Appendix A of Preferred Project and Response to Submissions Report – TPGNSW July 2010.

Summary of Issues Raised by DoP and other Agencies in letter dated 27/11/2009.

Figure 1; Bega Valley Shire Council Property Map

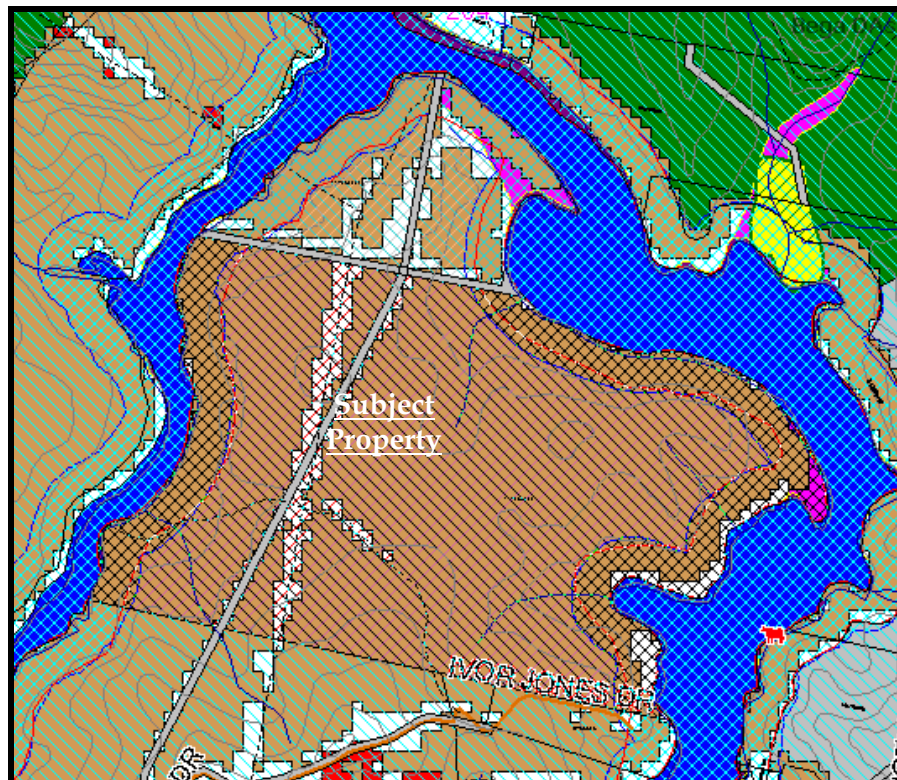
ISSUE RAISED:	
c) Flooding – the potential flooding hazard is briefly considered in the report in Appendix H (Section 7) of the EA. This assessment states that “flooding of the main road has occurred at a frequency of approximately once annually”. Clarification is required on which road is being referred to and the source of this information.

SCALE 1:8000	DATE 03-08-2009	DRN. SB	CHK. MS	SIZE A3
REFERENCE/DRAWING NAME				REV.
0833 B				15

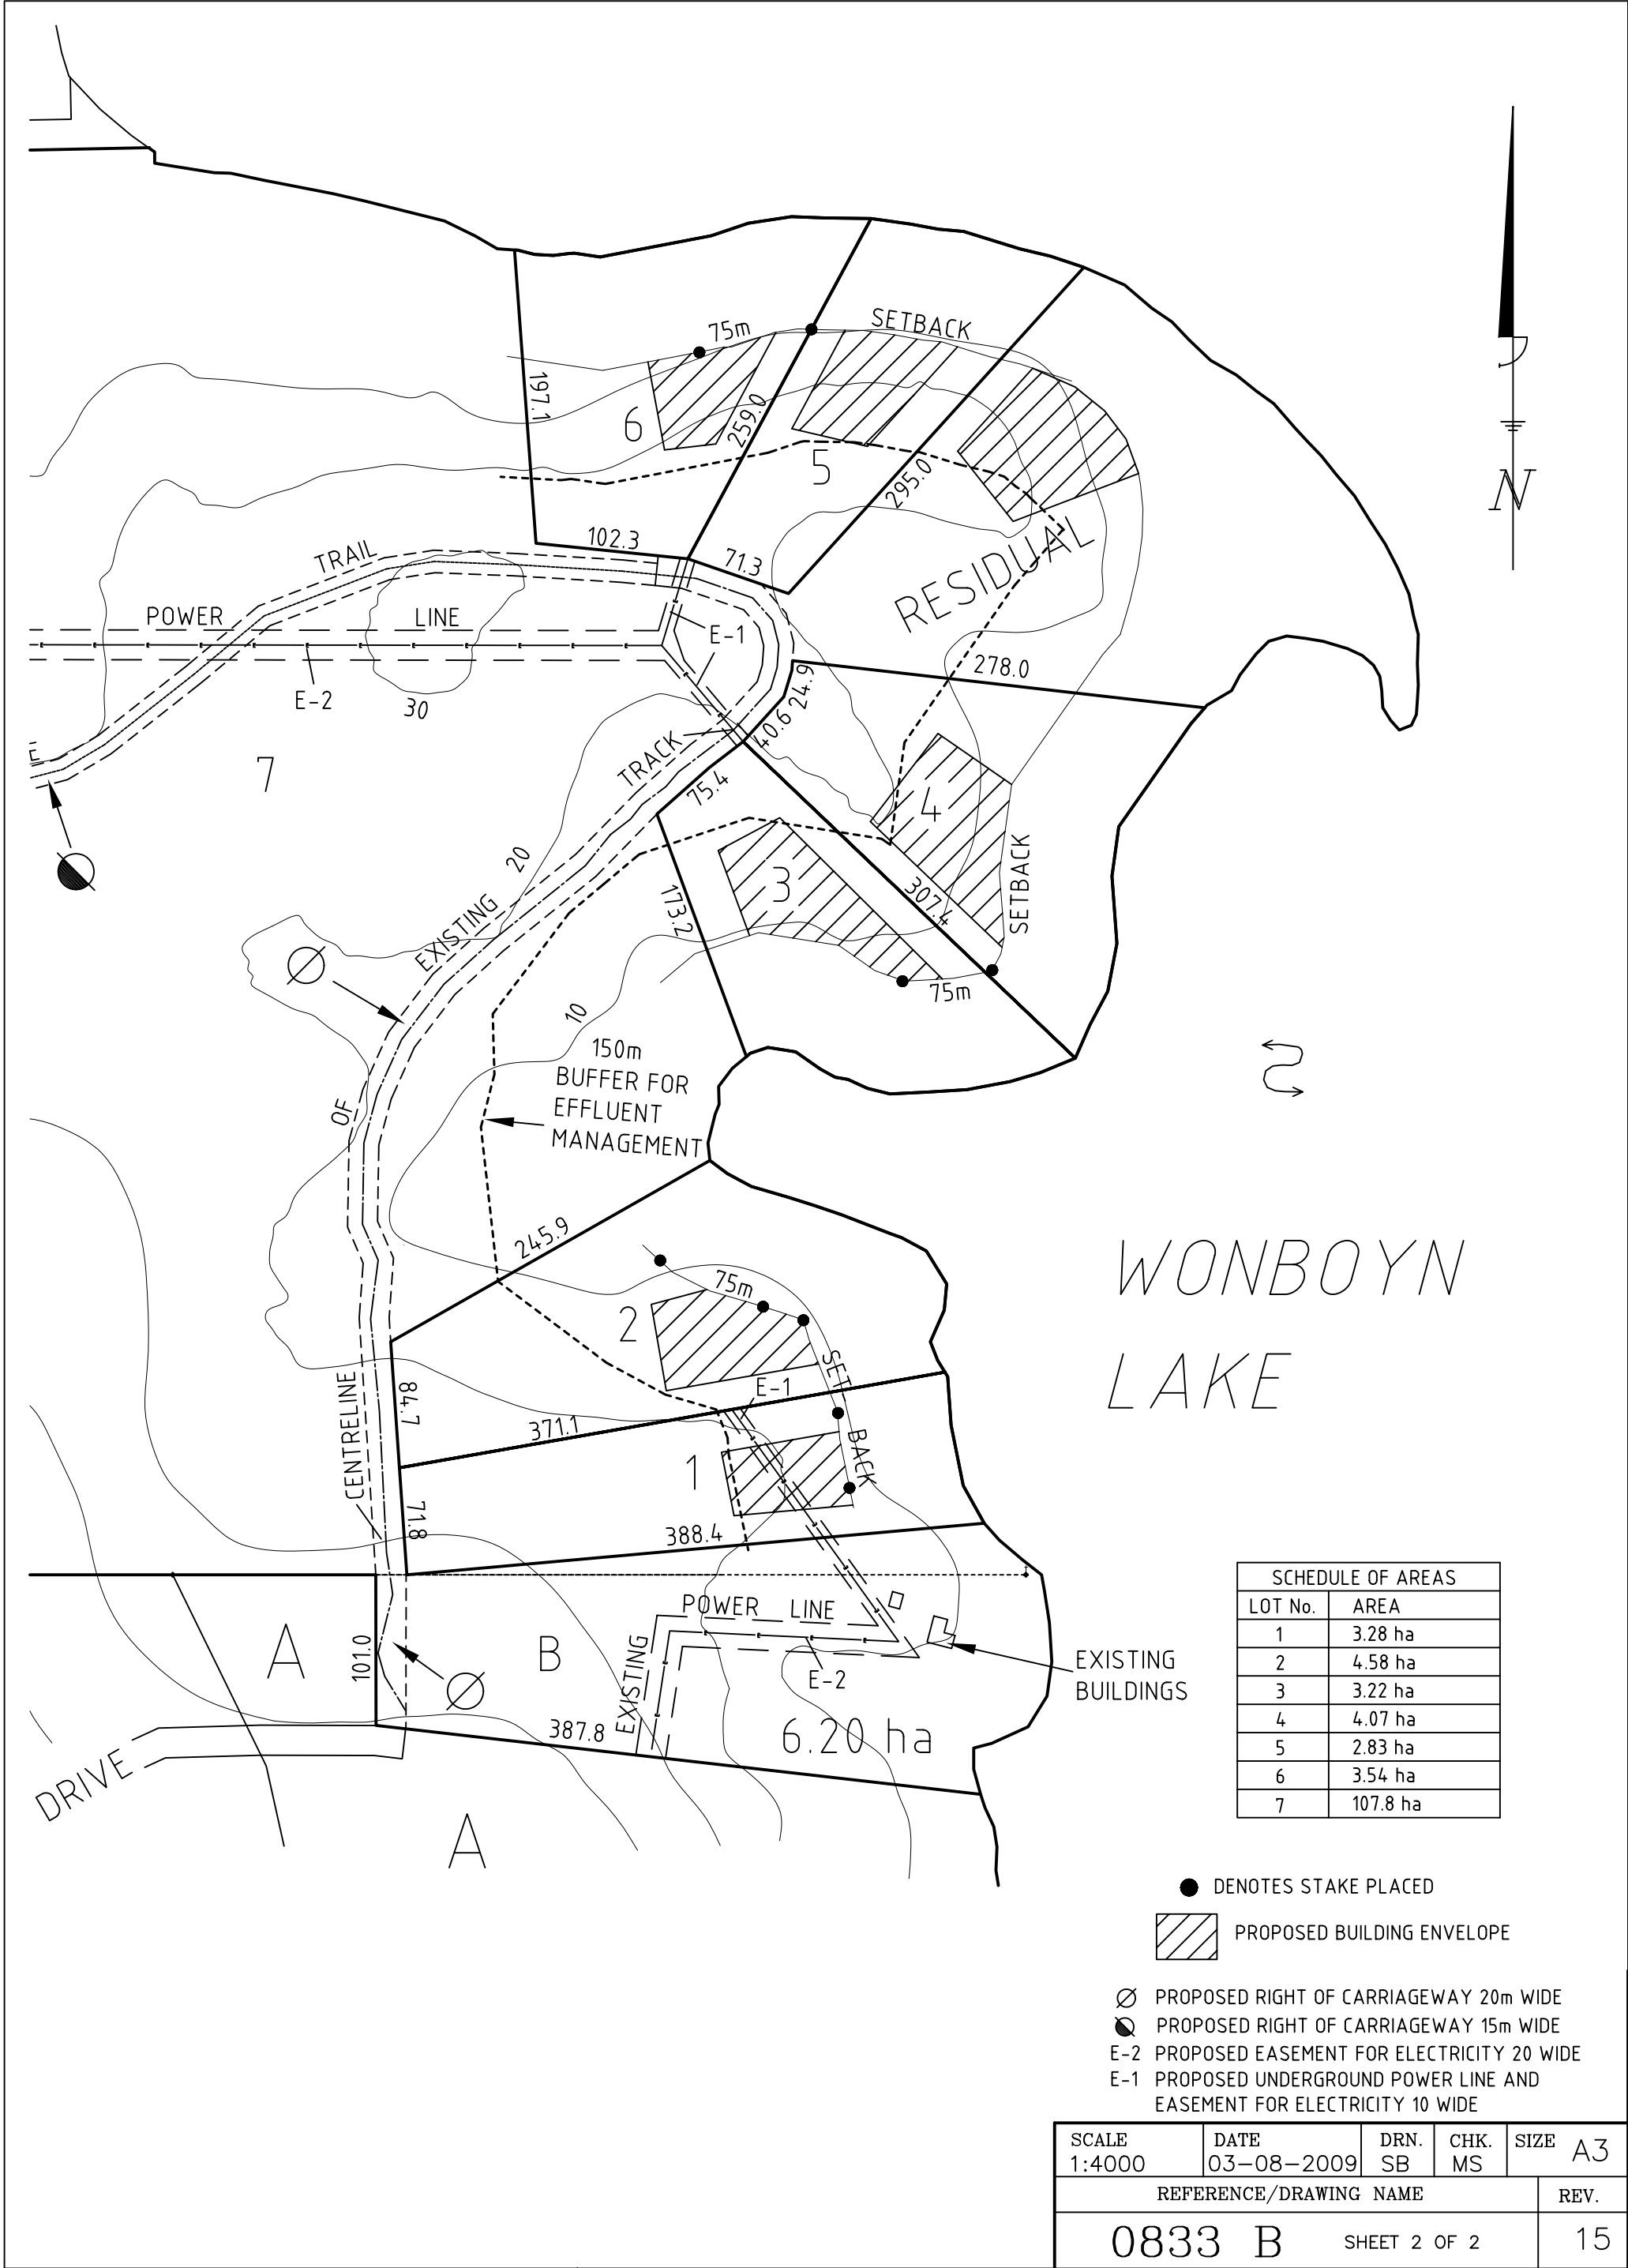
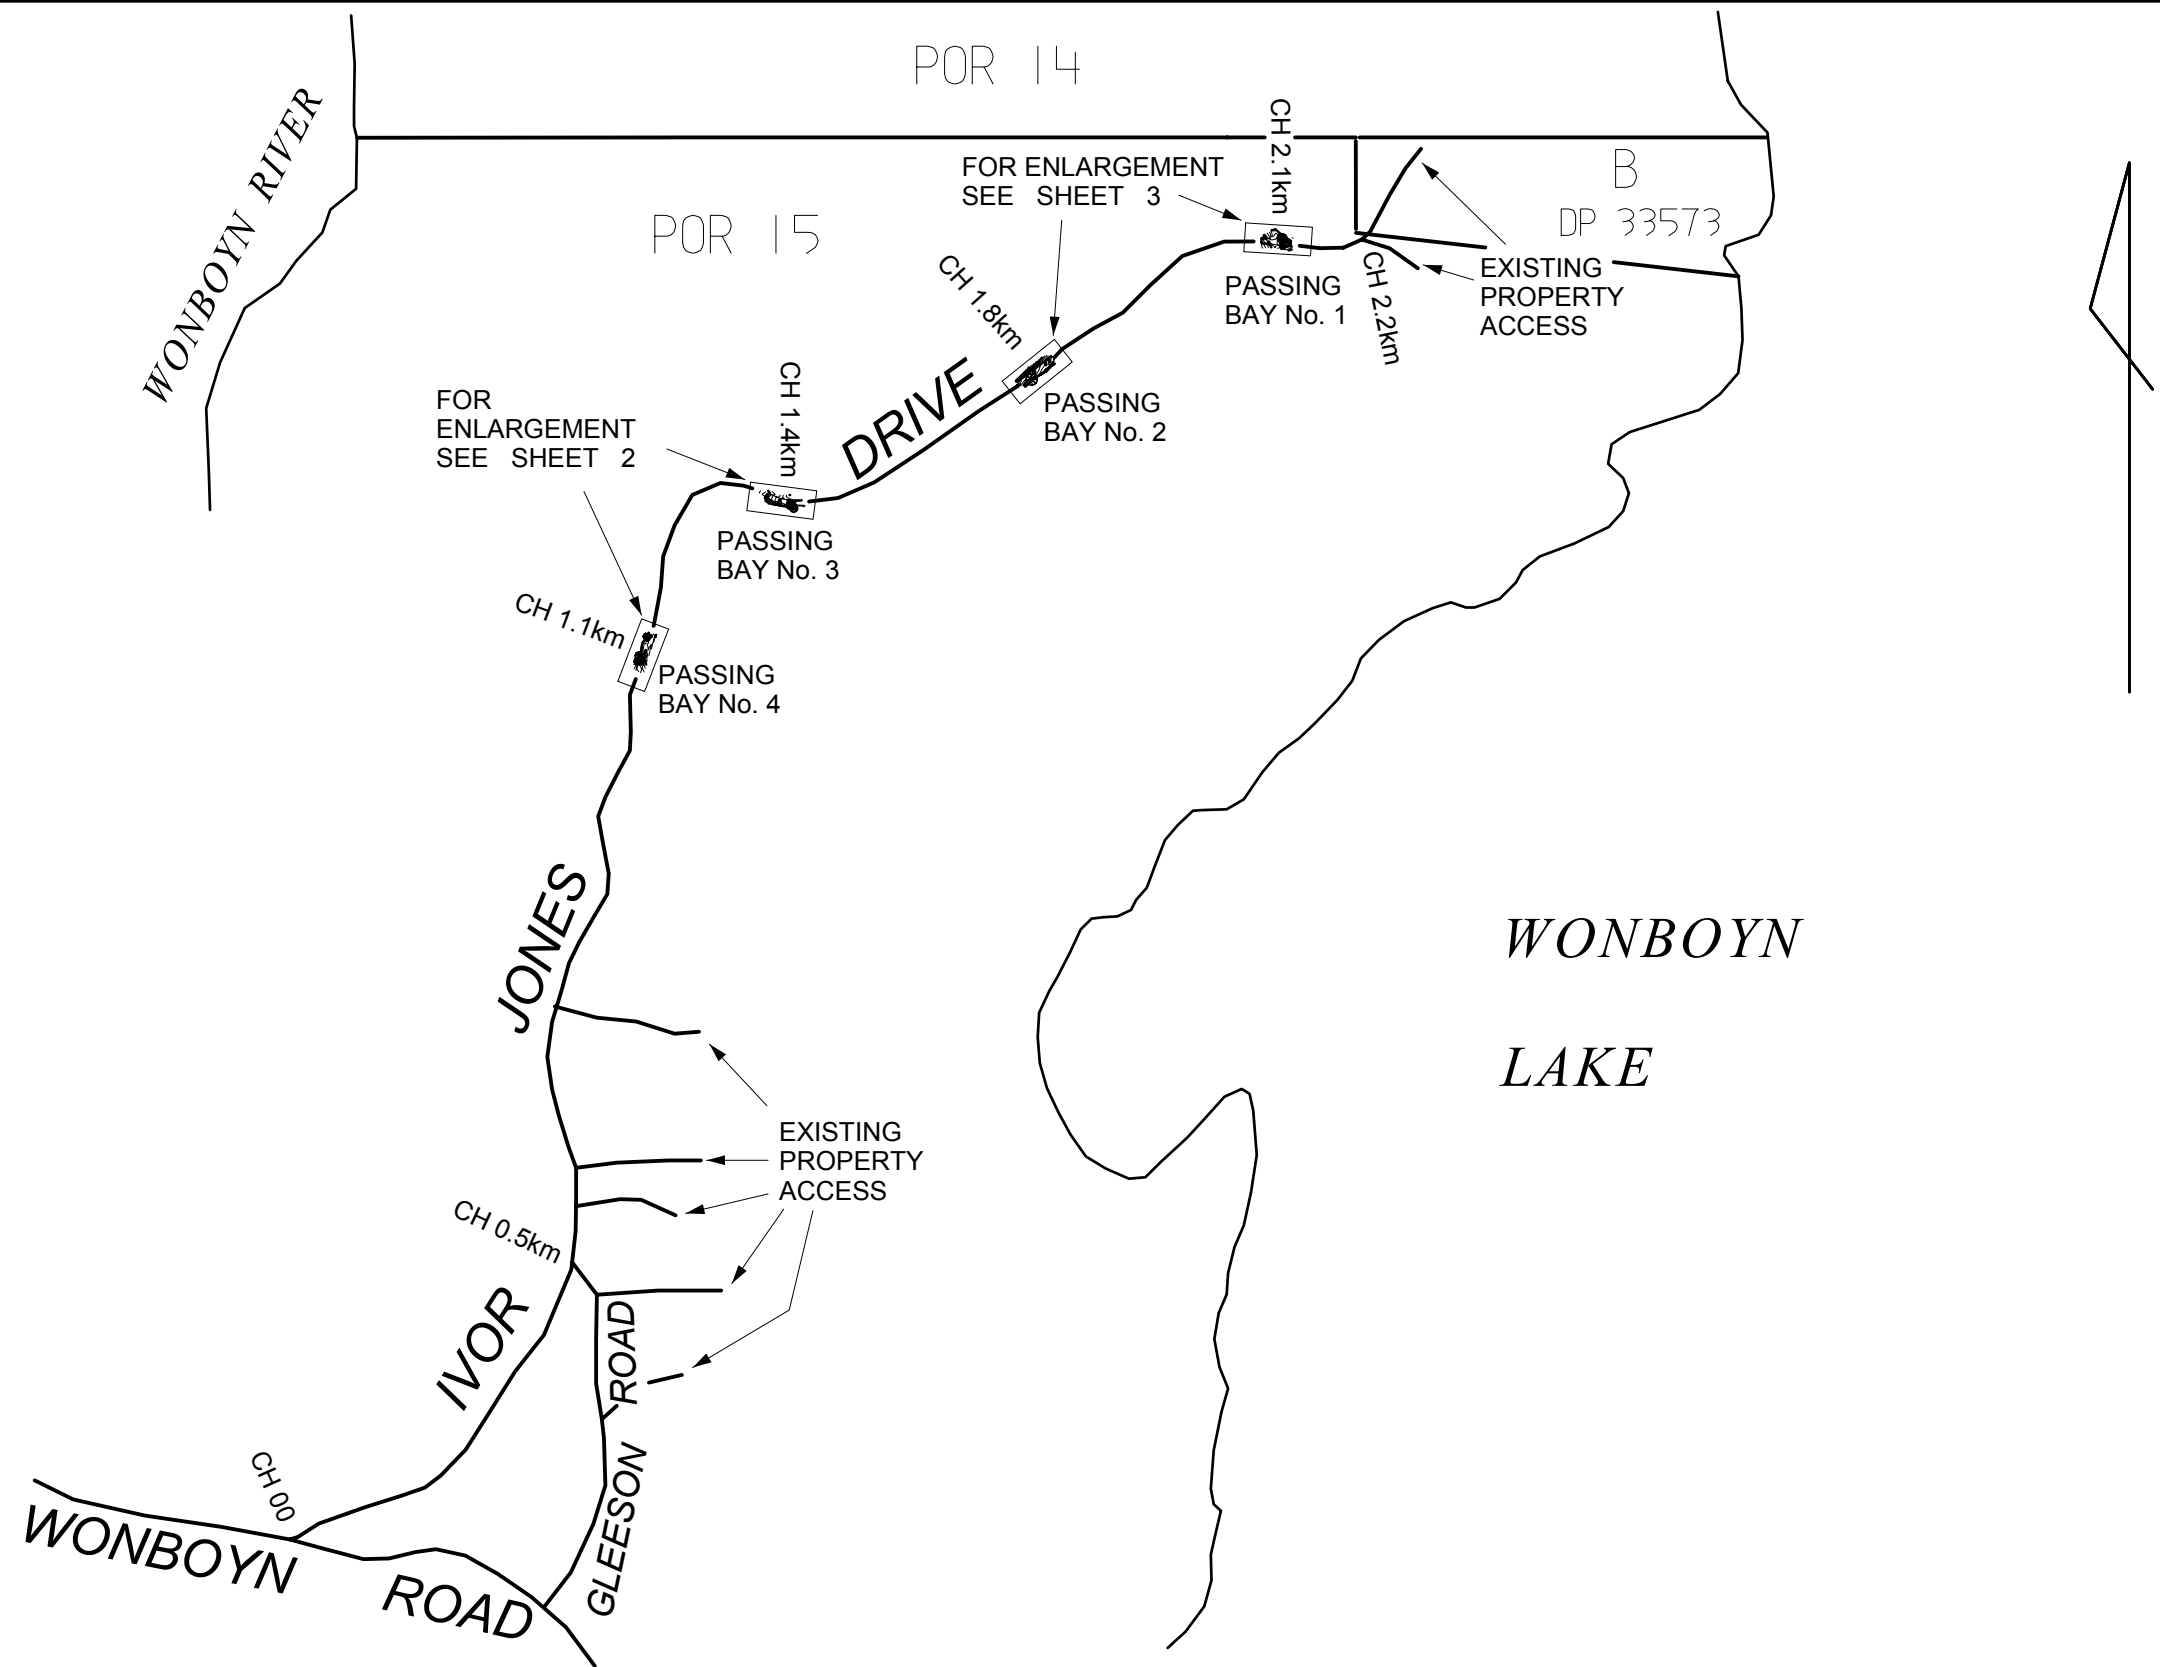
ISSUE RAISED:	
(iii)	<u>Core Riparian Zone</u> – a 40 metre Core Riparian Zone ("CRZ") is required to be provided from the mean high water mark across the lake frontages to the individual lots within the subdivision. This CRZ is to be provided as a Restrictive Covenant under the <i>Conveyancing Act 1919</i> and shall prohibit any buildings or land clearing in recognition of the scenic quality of the foreshore, the very high water quality in the estuary and the significance of the existing riparian vegetation.
(iv)	<u>Setbacks</u> – the setback to the mean high water mark for buildings is 75 metres and the setback for the effluent management areas is 150 metres as outlined on subdivision plan (Drawing No 0833B Sheet 1 of 2 Rev 15 dated 3 August 2009). The CRZ is to be included within the 75 metre building setback.

Figure 8 – Green Cape 6 min rainfall data 1974 - 1975

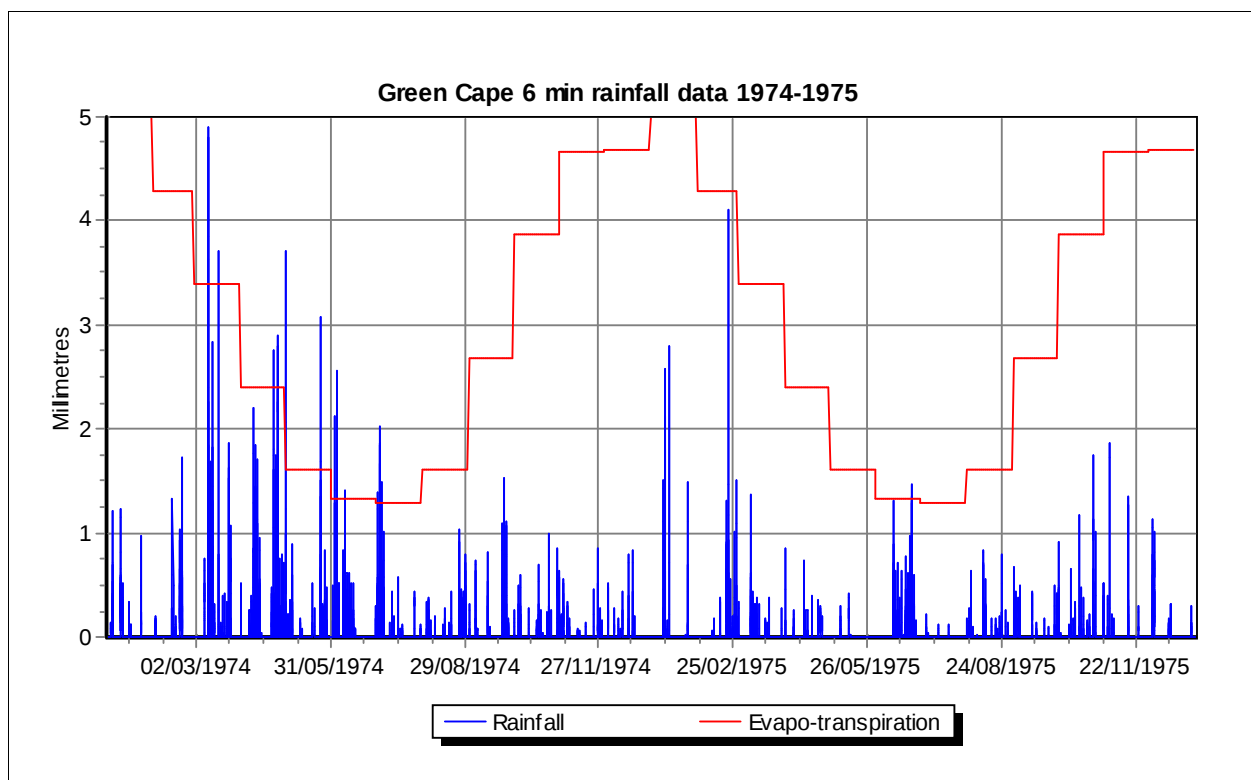
i. no phosphorous leak point for the soil has been established;
	ii. Green Cape rainfall data has been used in the Water Cycle Management Study. The data is statistically questionable given the size of the sample period used;
	iii. Council adopted DCP 6 – Minimum Setbacks requires a minimum setback of 150 metres from nominated waterways for the installation of on-site sewage management systems. There is conflicting detail which nominates a setback of 75 metres.
	iv. The report recommends one on-site sewage management solution that is a specific brand named system that may or may not be available in the future. The report should provide a minimum performance criteria for the design of future on-site sewage management systems as opposed to nominating a brand named system. Should the Department or the proponent wish to discuss the above points, please consult with Council's Senior Environmental Health Officer Mr. Jonathon Pyke (6492131).
